Commitment Letter

Project Name: Walden Preserve 2, Filing #4

Description: It is proposed to develop Walden Preserve 2, Filing #4 with 23 single family residential lots and two tracts on a 45.27 acre parcel. This development is located east of State Highway 83 and south of Walker Road in Sections 14, 15, 22 and 23, Township 11 South, Range 66 West.

DRAWING: 17094FP4.DWG PAGE 1 OF 2

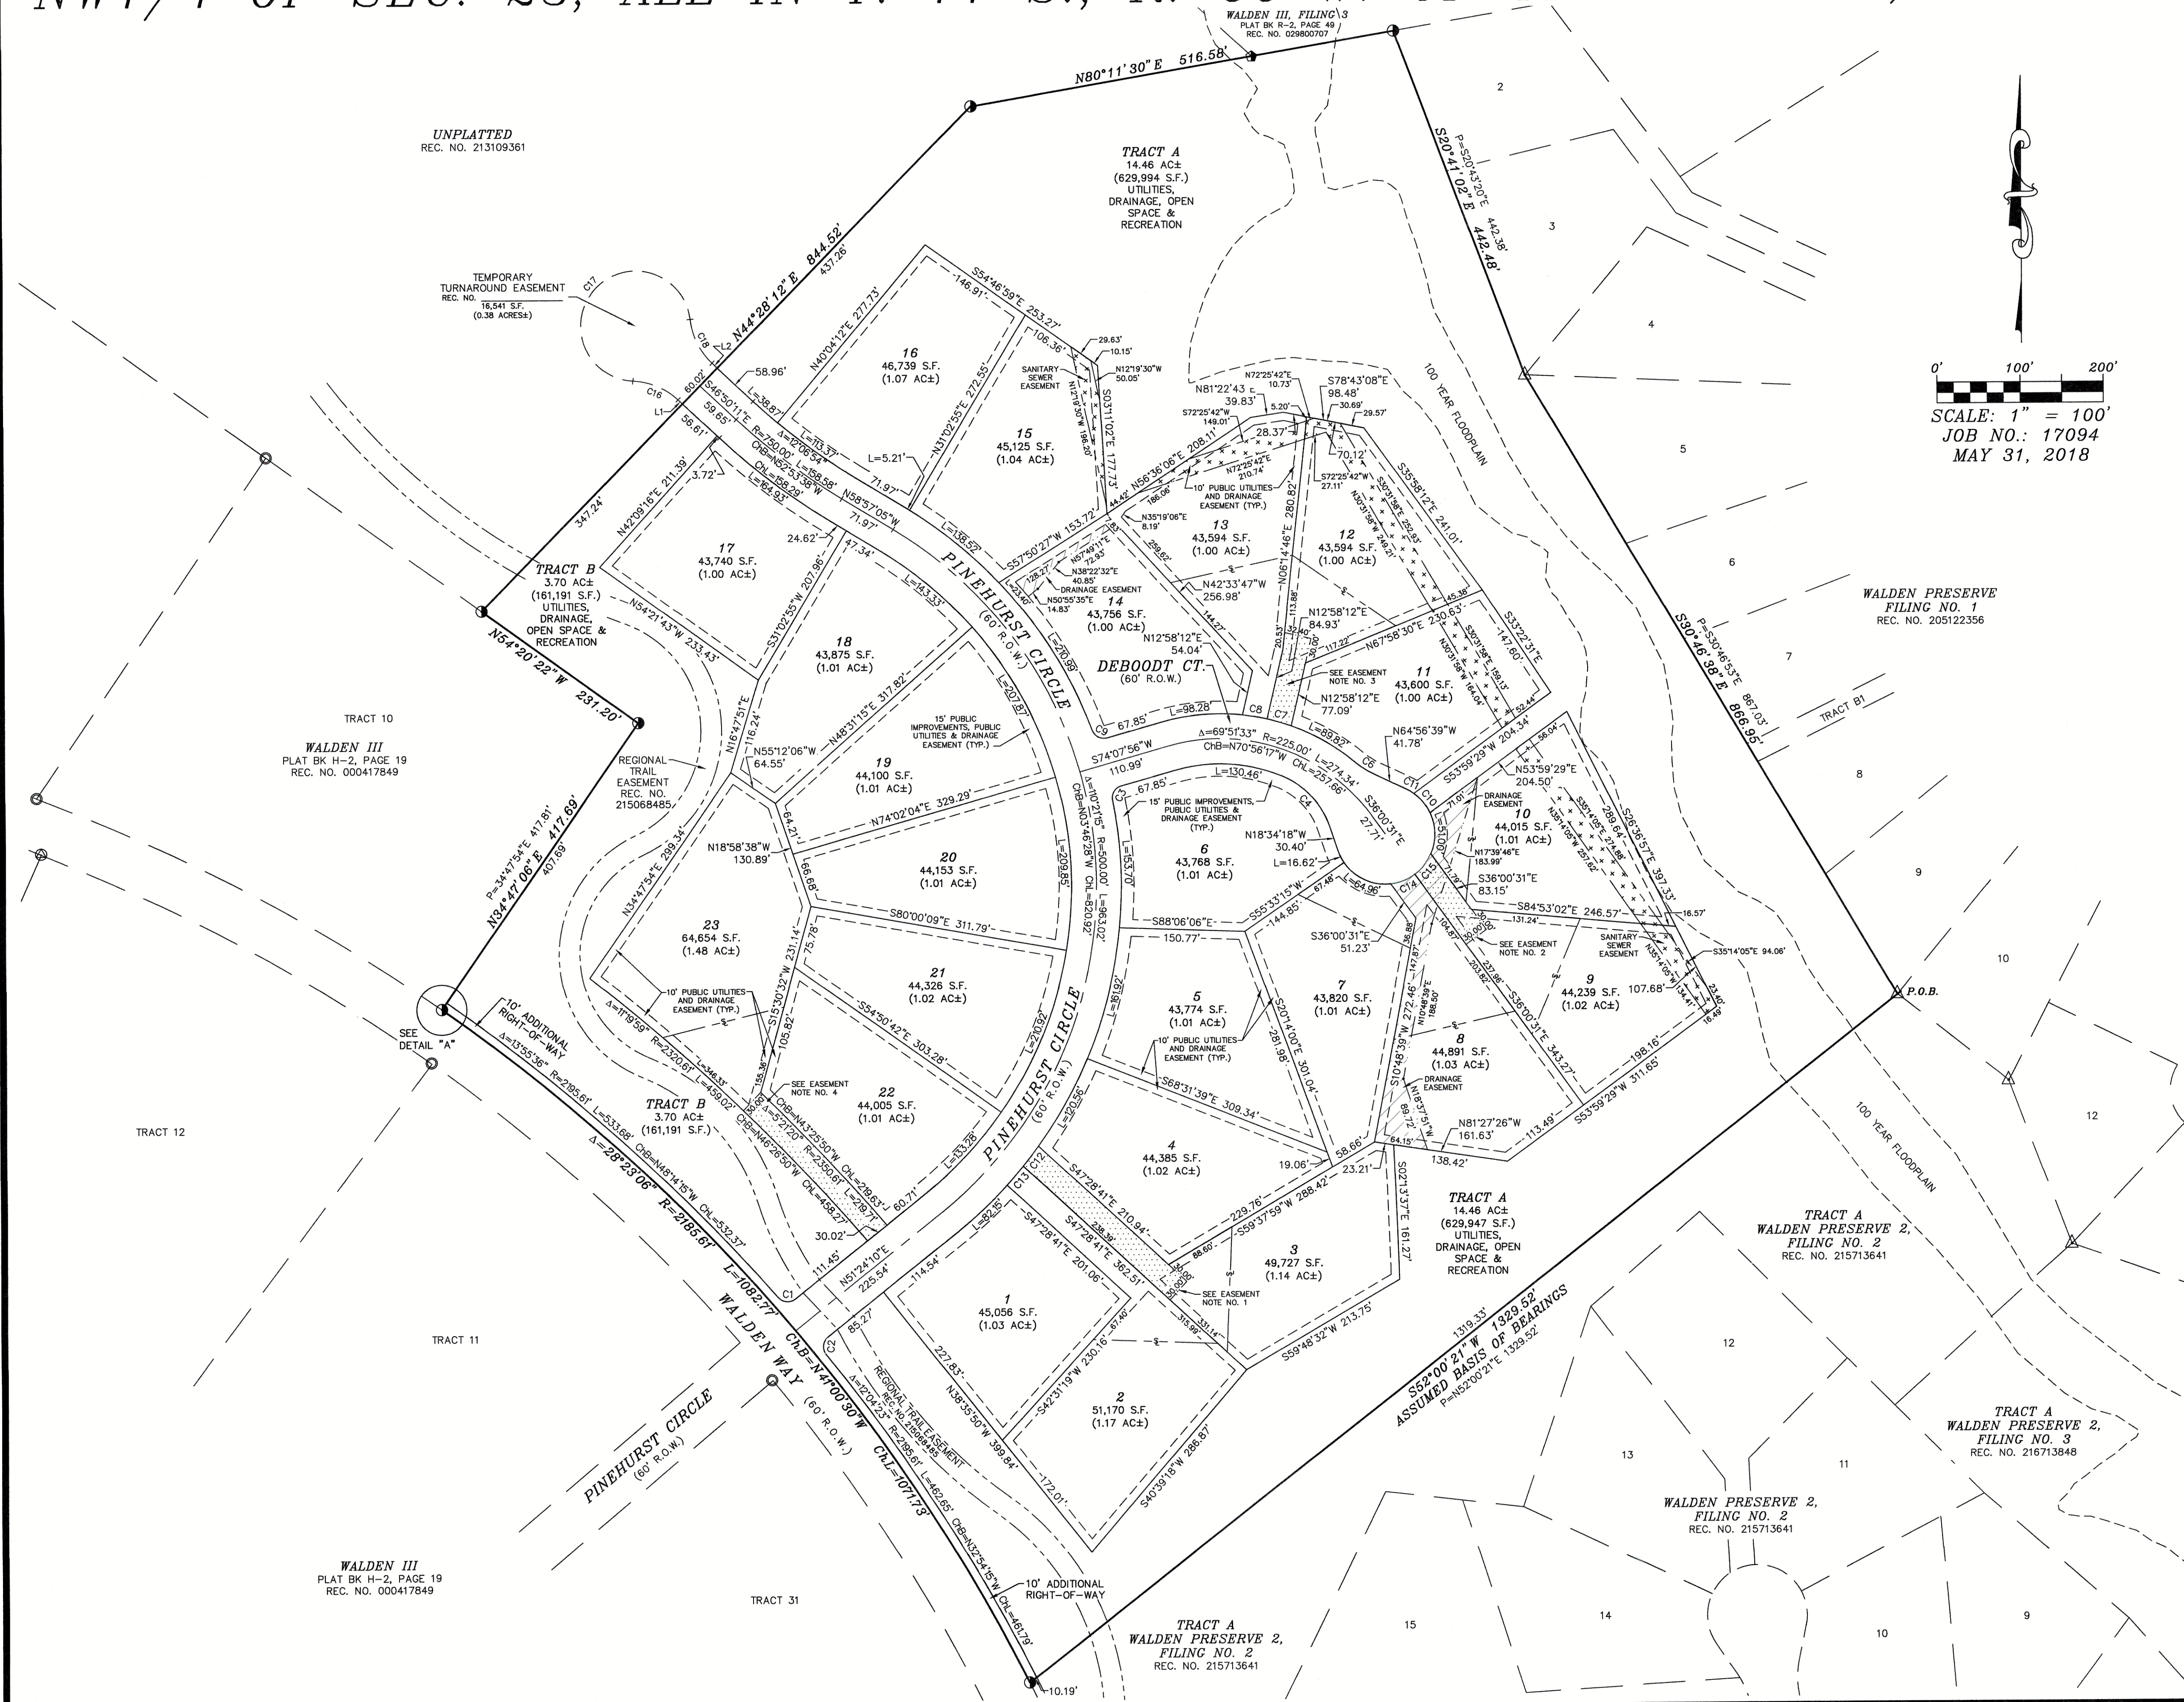
MVEA requests utility easements of ten (10) foot side and rear along with fifteen (15) foot front lot line utility easements to align with previous filings of Walden Preserve. If open space, drainage and landscape tracts are designed in this filing, MVEA requests these areas be listed to include utilities to allow for design to all lots.
